Hunter Water Corporation  
ABN 46 228 513 446

14 April 2020

Our Ref: HW2019-913

**RE: STOCKTON SAND QUARRY – REQUEST FOR ADVICE REGARDING ENVIRONMENTAL IMPACT ASSESSMENT (SSD-9490)**

Figure 3-3: Overview of staging plan for the Project

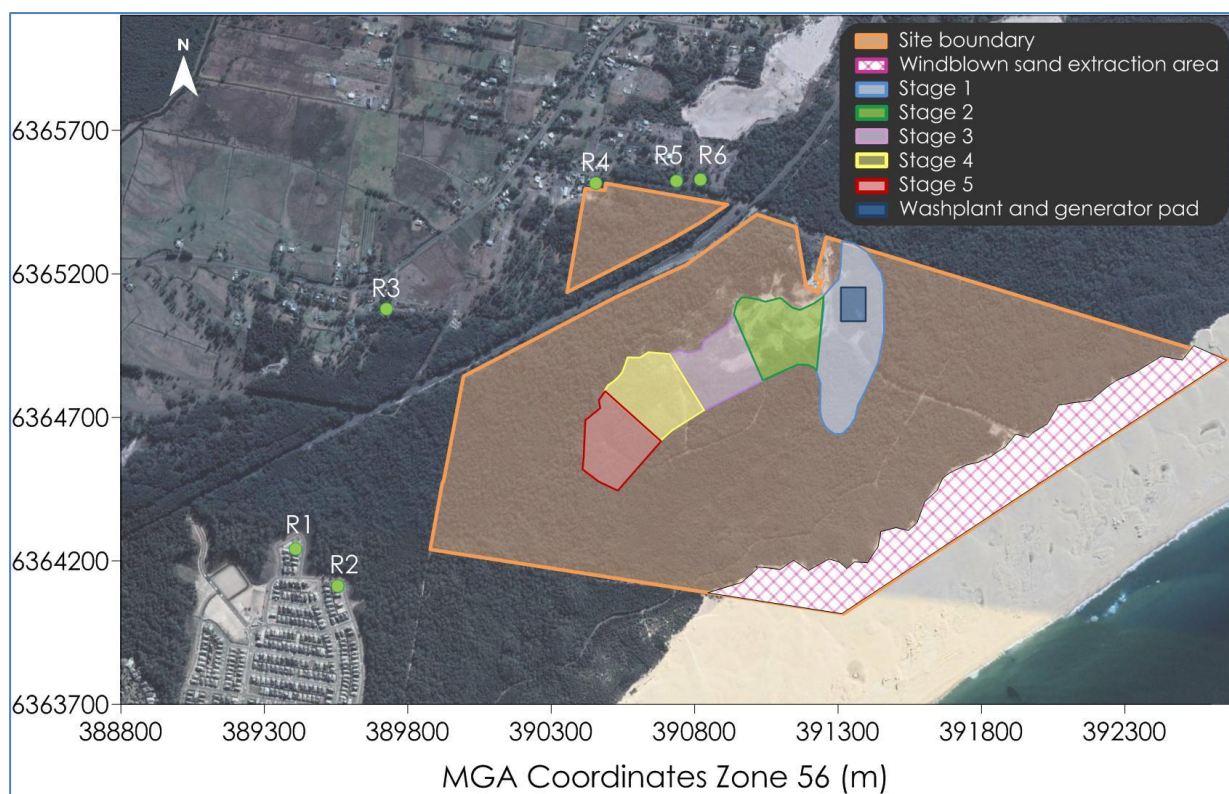
In regard to best management practice, we note that the proposal to extract sand below the water table to -15 metres AHD is inconsistent with current best practice and the approval of

other sand extraction operations in the area, which have limits on the depth of extraction imposed upon them in order to protect groundwater sources.

Best practice for existing operations is considered to be extraction to a depth of no more than 0.7 metres of maximum predicted groundwater levels, with the final landform to be a minimum of 1 metre above the maximum groundwater level. For example, sand extraction at the Sibelco Tanilba Northern Dune operation, the Sibelco Anna Bay operation, the Cabbage Tree Road Quarry (SSD-6125), Salt Ash Sand Quarry (07\_0094), and the Fullerton Cove Sand Quarry (07\_0145) all have extraction depth limits imposed upon them to safeguard groundwater sources. Measures to protect groundwater sources are related to both pollution risk and the loss of valuable water supplies through drainage and evaporation.

Hunter Water recommends that all extractive operations should be designed and undertaken in a way that ensures protection of water sources and facilitates sustainable future land use. Hunter Water is of the opinion that inadequate justification has been provided for why this particular sand resource justifies extraction below the water table, or for the creation of a 23.3 hectare open lake following the completion of sand extraction, which would result in the loss of around 130 million litres of fresh water per year due to evaporation.

Limiting the depth of sand extraction to above the water table with a suitable buffer would be consistent with the determination of other sand extraction activities in the vicinity and is supported by Hunter Water. It is Hunter Water's position that the approach adopted for other sand extraction operations in the area, where the extraction depth is limited by the requirement to create a final landform that is at least one metre above the predicted maximum groundwater elevation, is the only scenario which is considered suitable.
